From: Steven King [REDACTED]  
Sent: 10 October 2022 13:27  
To: Connor Smalls [REDACTED]  
Subject: Re: 22/01559/F The Ivatings, Tower Road, Burnham Overy Staithe.

Steven  
Steven King  
Conservation Officer  
Borough Council of King's Lynn and West Norfolk  
[REDACTED]

Subject: 22/01559/F The Maltings, Tower Road, Burnham Overy Staithe.

Drawing: Existing east & west facades  
Scale: 1:150 @ A4

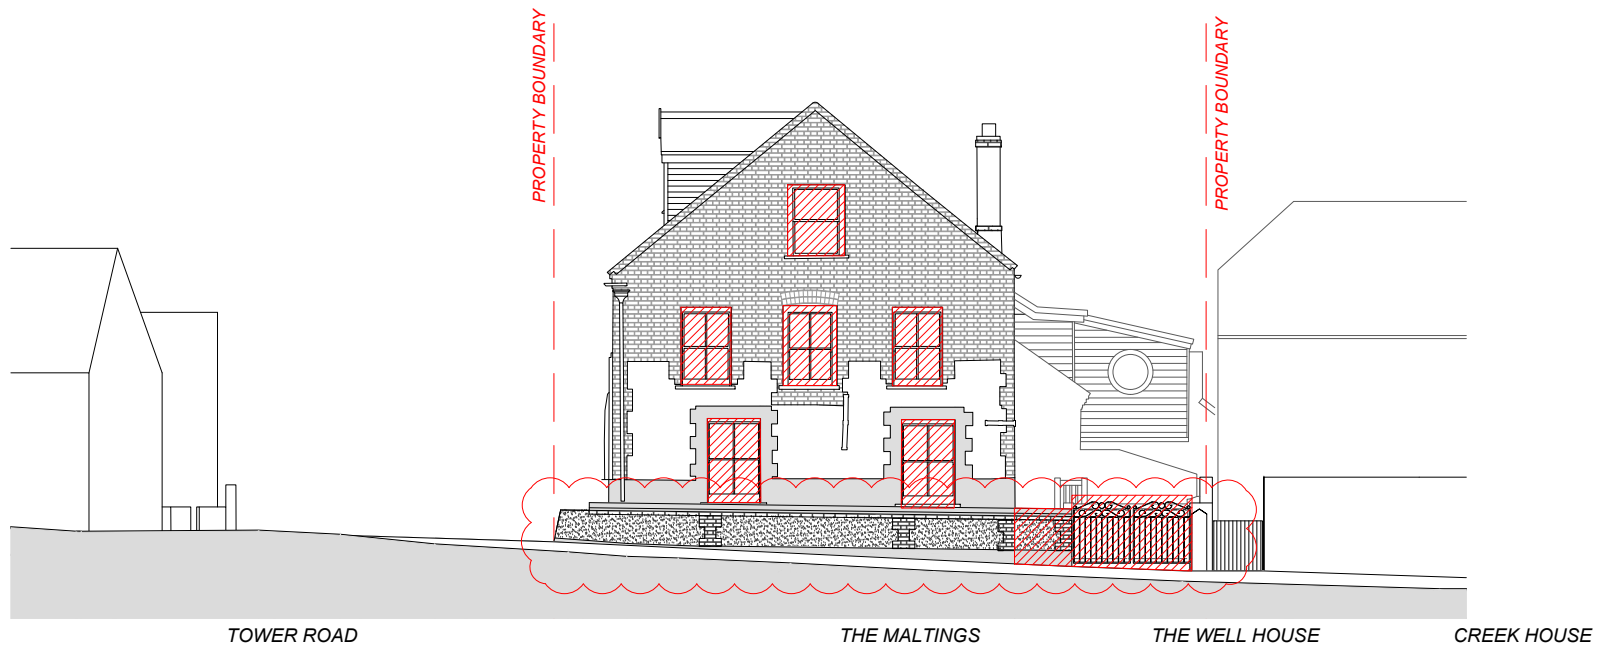
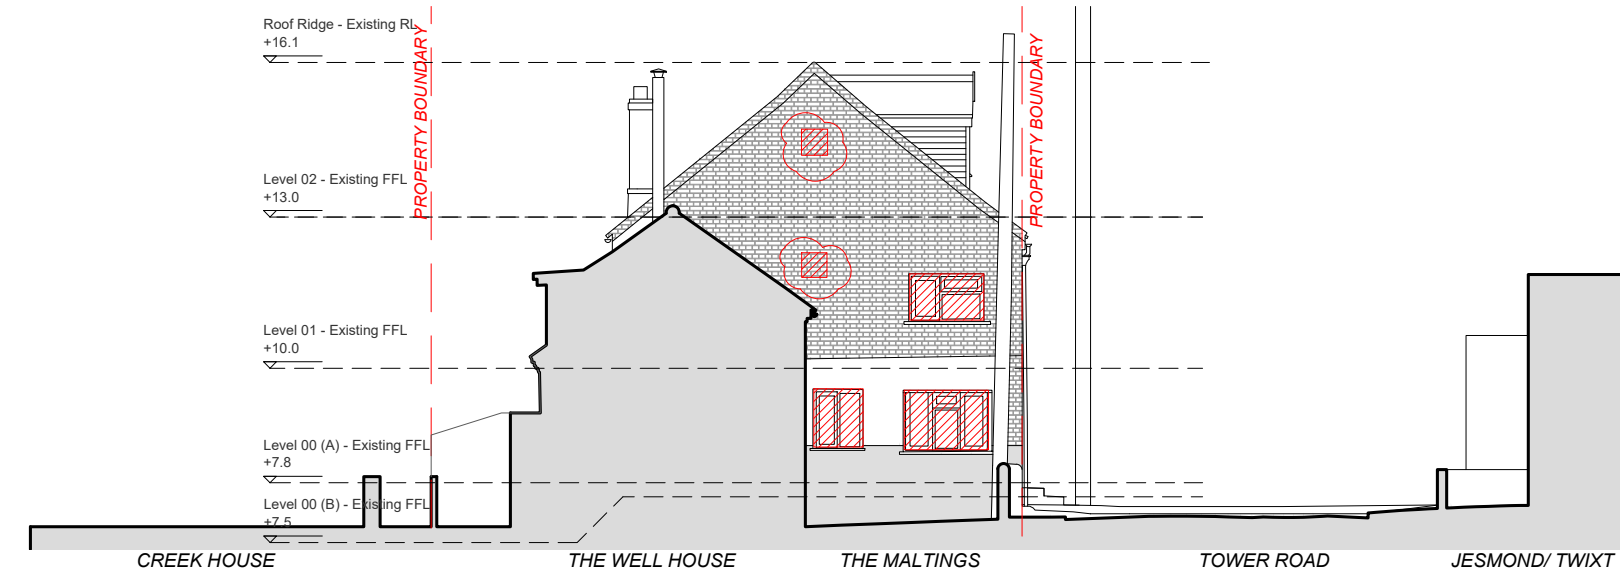
However, I am still not convinced by the window styles to the north and west elevations.

In the current form the windows look blank and featureless, unlike other windows in the locality. Some introduction of glazing bar would help along with more confirmation that the windows are to be recessed within the masonry.
